DECISION DELEGATED TO HEAD OF PLANNING

Application No: H11-0835-23 **Applicant:** Mr A John

Proposal: Extension & Alterations - approved under H11-0445-22. Modification of Condition 2 to allow amendments to previously approved plans.

Location: 30 Roman Bank Long Sutton Spalding

FRONT ELEVATION.

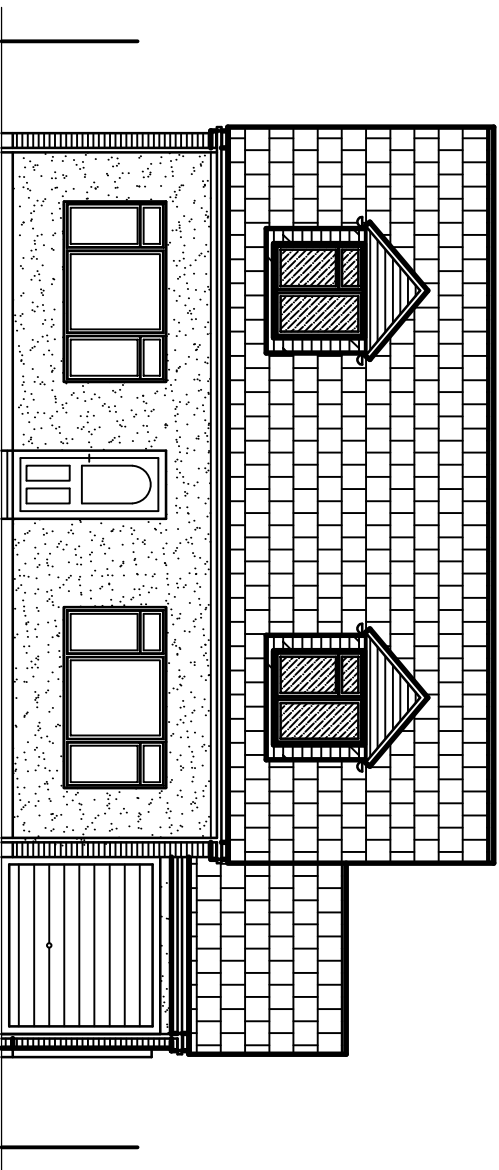
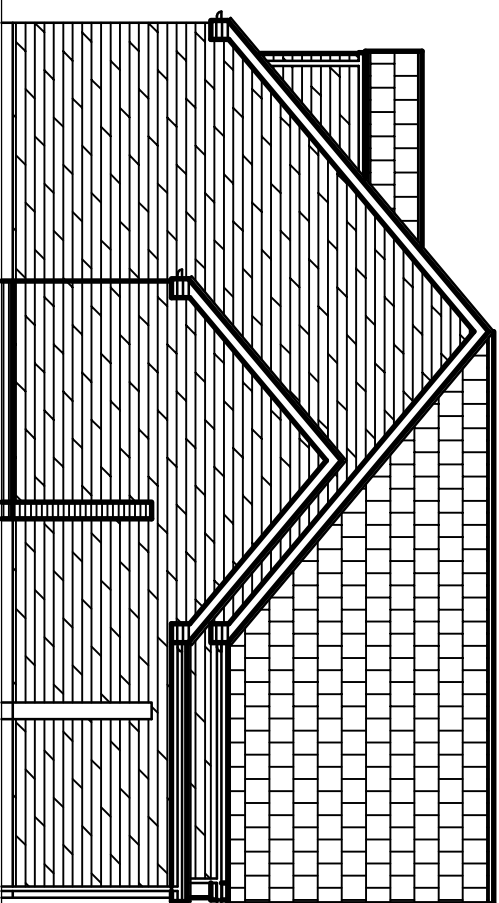
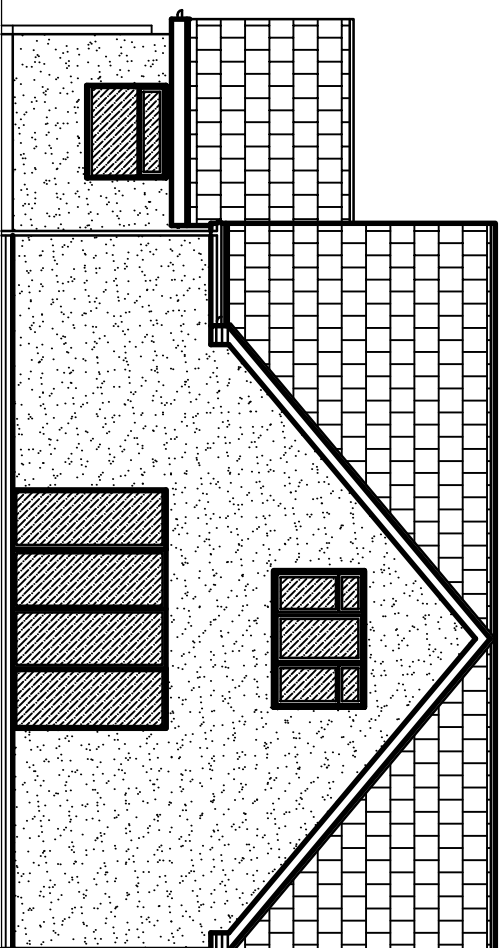
This application proposes to change the materials that will be used on the extension and alterations, for the most part the materials will be the same as what has previously been approved however there are a few minor changes to the approved plans. On the front and rear walls a k-rend in ash white will be used, this is the same as what was already approved. The windows are also the same and these will be made of uPVC in anthracite grey, similarly the doors will be the same material in composite steel Chartwell green. Finally, the changes proposed to the materials are the sidewalls which will now be made of an anthracite grey cladding, this will match the materials and colour on the windows and therefore it is considered to not drastically stand out when compared to features on the dwelling. The brickwork detailing will be Vandersan Old Farmhouse where as before it was Audley Antique, these two bricks types are very similar in design and therefore the change is not significant enough to cause an issue on the street scene or locality. On the previous approved plans there was a two sets of French doors, this will now be changed into one set of bi-fold doors and as such the rear wall will extend longer into the centre of the wall to make the width of the door shorter.

REAR ELEVATION.

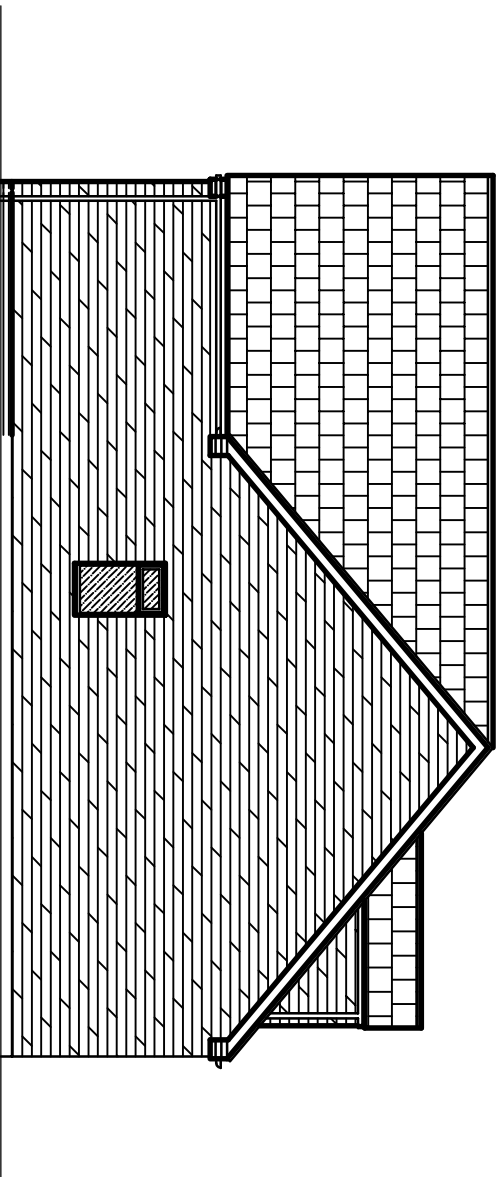
There is no change to the height or size of the building as the proposal is to only change the materials being used with a slight alteration to the layout of the rear elevation, as such there will be no overlooking or overshadowing that will arise following the new development being carried out. It is therefore considered to be in accordance with Policies 2 & 3 in terms of the impact upon the residents nearby.
